Environmental Impact Statement- Rocky Hill Coal Project (SSD-5156)

Reference is made to correspondence received on 12 August 2016 from the Department of Planning and Environment (DP&E) requesting written comments from the Environment Protection Authority (EPA) for SSD 5156 (the amended Rocky Hill Coal Project). Attached to the correspondence was the document titled: *"Amended Rocky Hill Coal Project Environmental Impact Statement Development Application No SSD-5156 (August 2016)"* (the EIS) prepared by R.W Corkery and Co Pty. Ltd.

ATTACHMENT 1

Figure 1 - Contours predicted for year 7 of the project (adapted from Appendix O3 of SLR 2016).

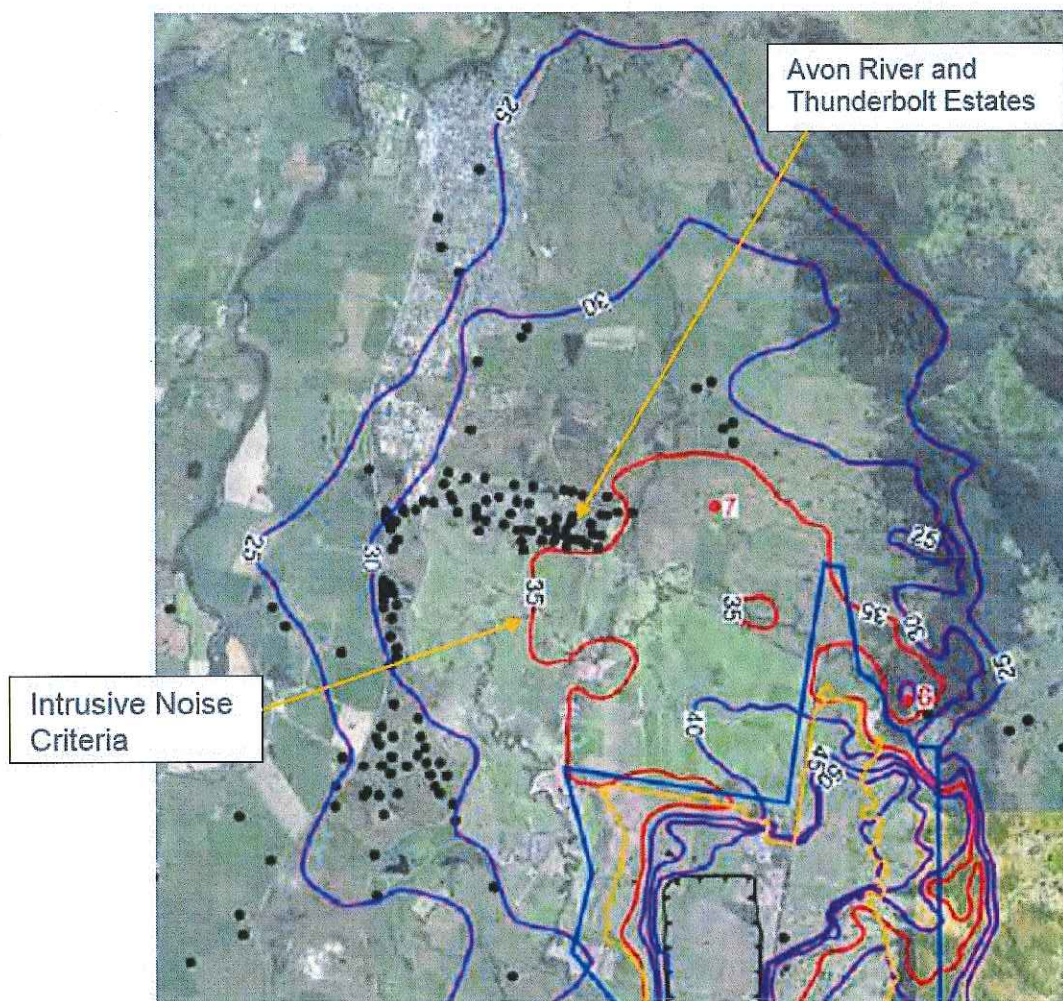
- Figure 1 shows the noise contours predicted in the EIS for Year 7 of the project.
- The EPA notes from the noise modelling conducted that despite the changes made to the project since 2013 the predicted noise contour representing the intrusive noise criterion ($L_{eq(15min)} 35$ dBA) just skirts around the Avon River and Thunderbolt Estates for two of the modelled scenarios.
- There is always some uncertainty in noise modelling. The EPA highlights to DP&E that the number of residences receiving noise above the intrusive noise criterion could be significantly greater than predicted if:
 - noise levels were slightly under-predicted, or
 - not all necessary mitigation measures are implemented to meet the noise limits.

- The 2013 EIS suggested that inversions would occur in the evening period (6:00 pm to 10:00 pm) in Gloucester about 20% of the time in winter.
 - The EPA highlights that although the noise assessment has been conducted in line with the *Industrial Noise Policy*, due to the expected strength and frequency of inversion conditions in the Gloucester Valley, the modelling may have under-predicted noise levels at residential sensitive receivers up to about 20% of the time, or for one winter evening in every five.
